Application for a Non-Material Amendment Following a Grant of Planning Permission

Proposed extensions and alterations to include two-storey front extension, single storey rear extension, single storey link side extension adjoining proposed two storey garage with bedroom in roofspace and the construction of a new gated vehicular access and driveway

3/2025/0773

Garage moved slightly further back (from front Elevation 1990mm to 2090) and made deeper on plan (from 6900 to 7600) to enable the provision of 2No dormers in lieu of Velux windows.

Proposed Site, Block and Roof Plan  
1 : 200

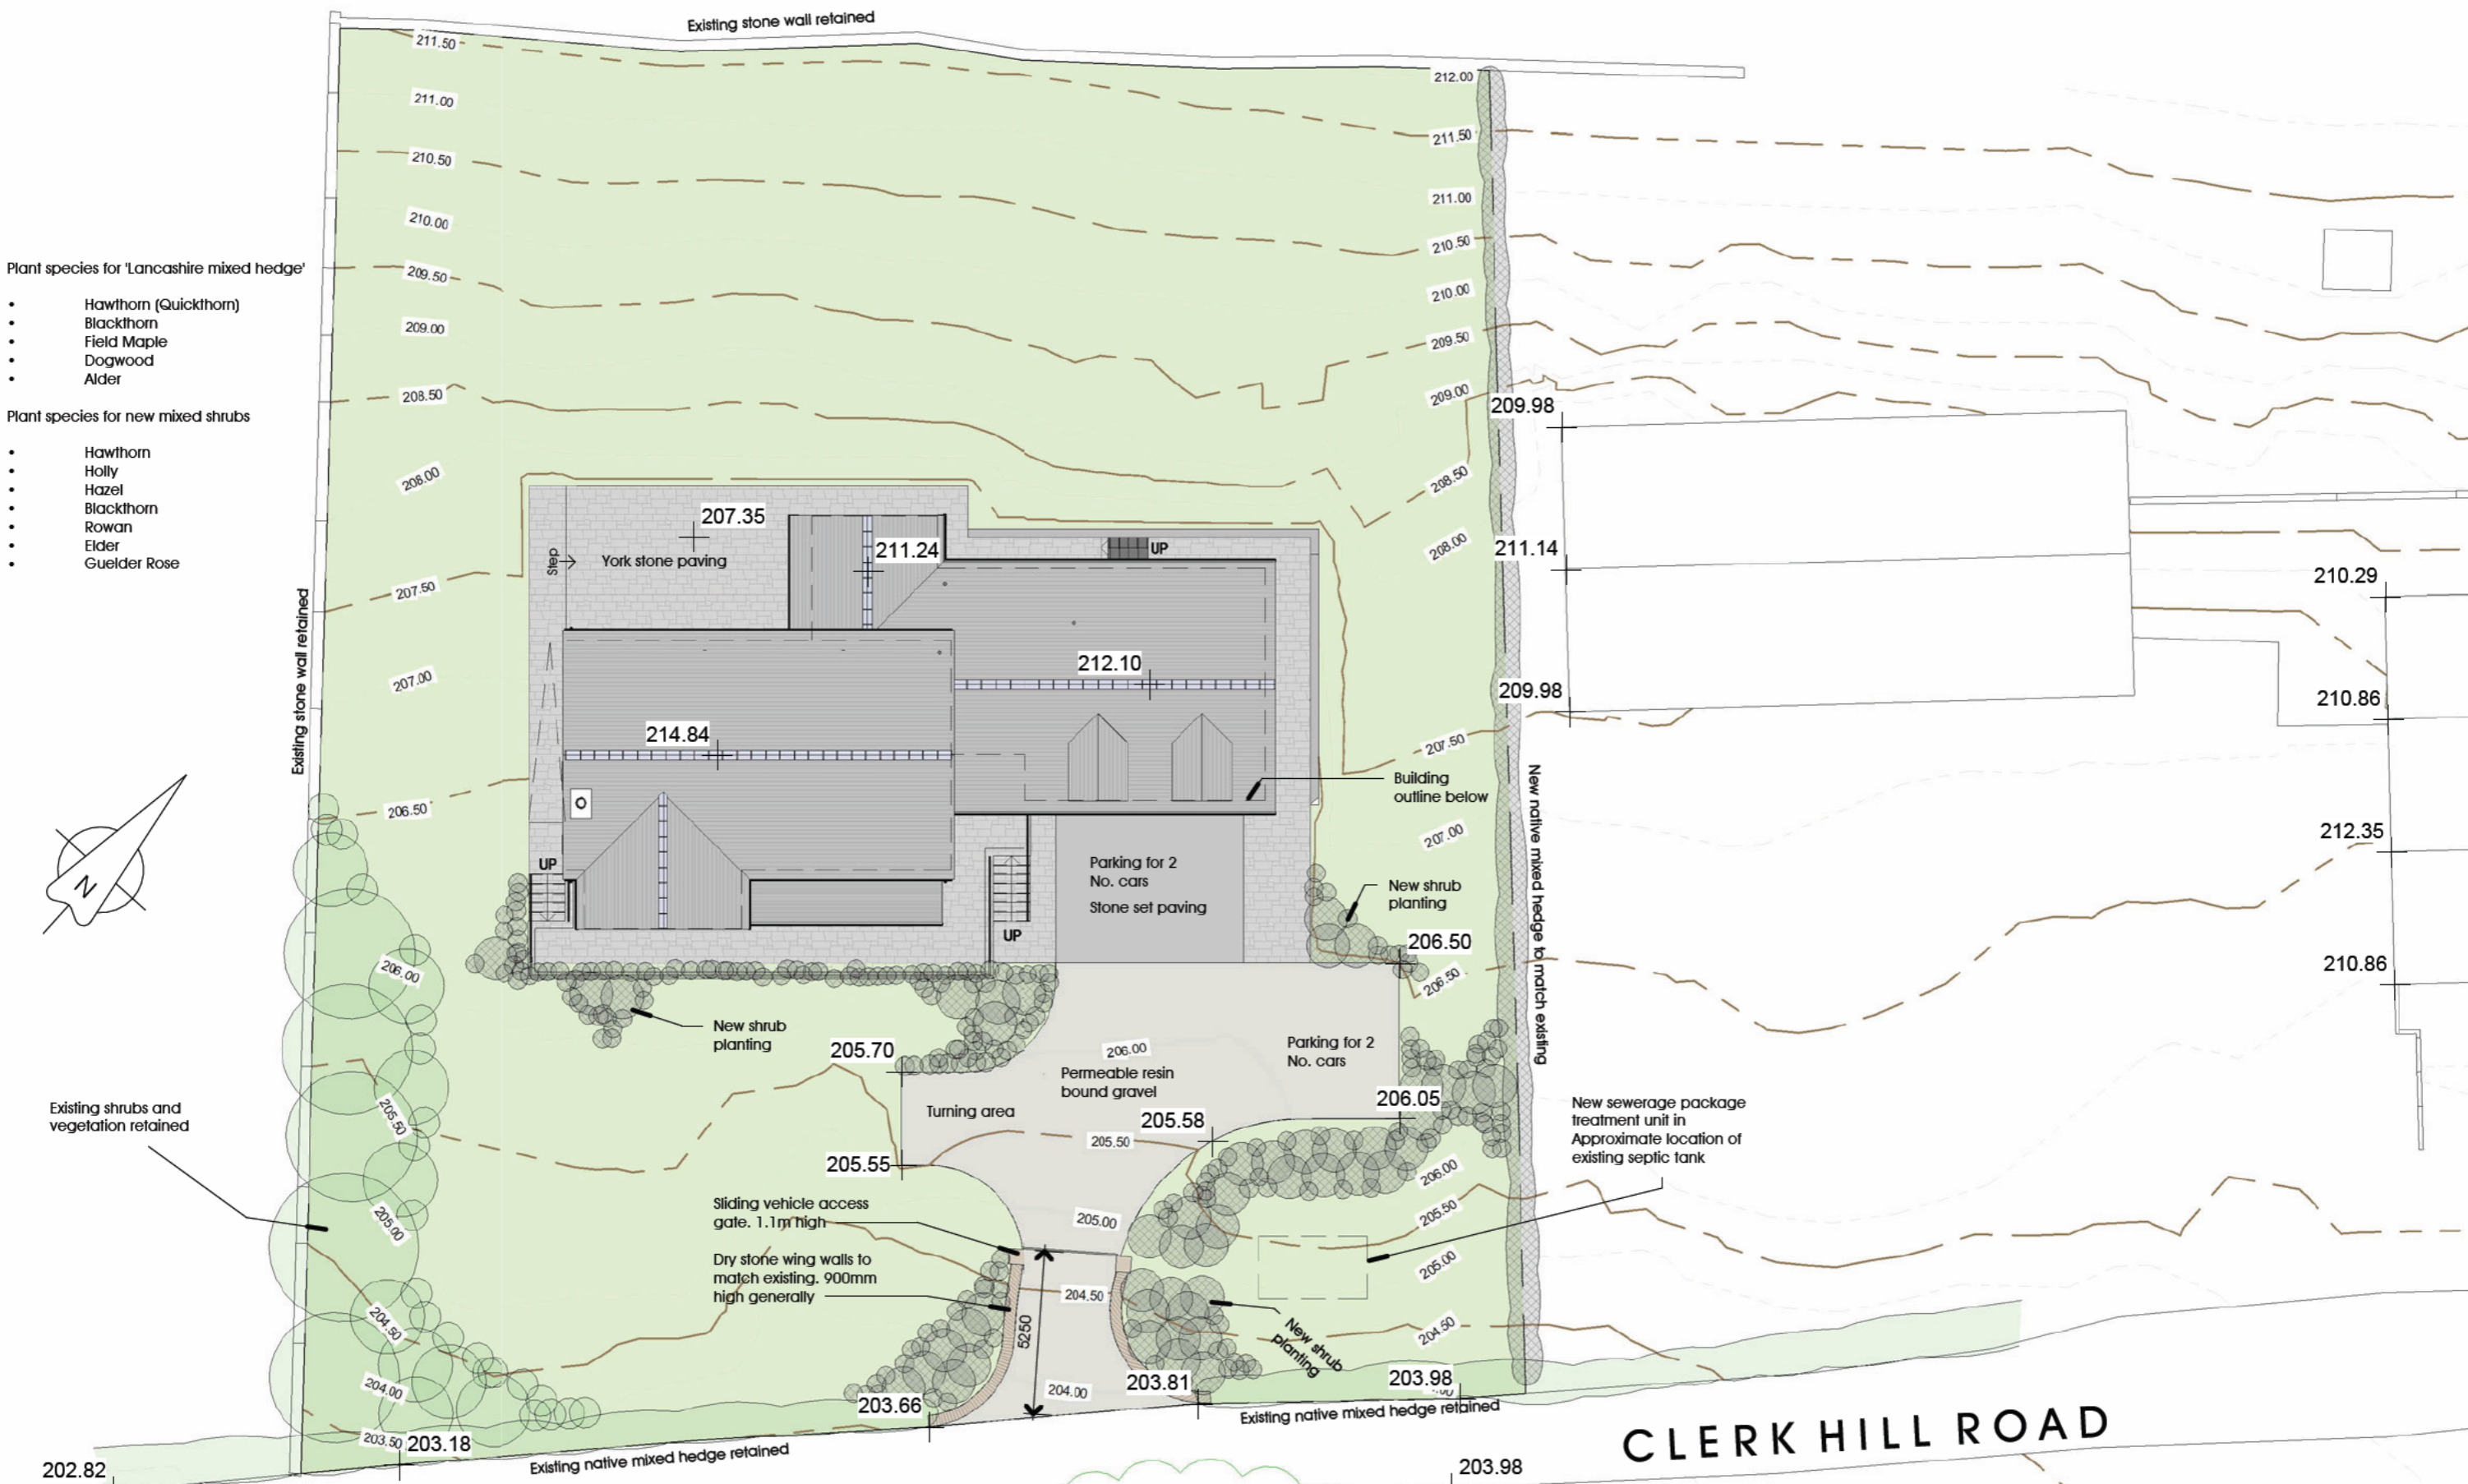
The adjustments to the garage takes account of practical retaining wall design. The dormers are to allow views over the exceptional landscape where Velux windows cannot achieve this. The Velux windows as approved cannot be used for escape purposes because they are too high.
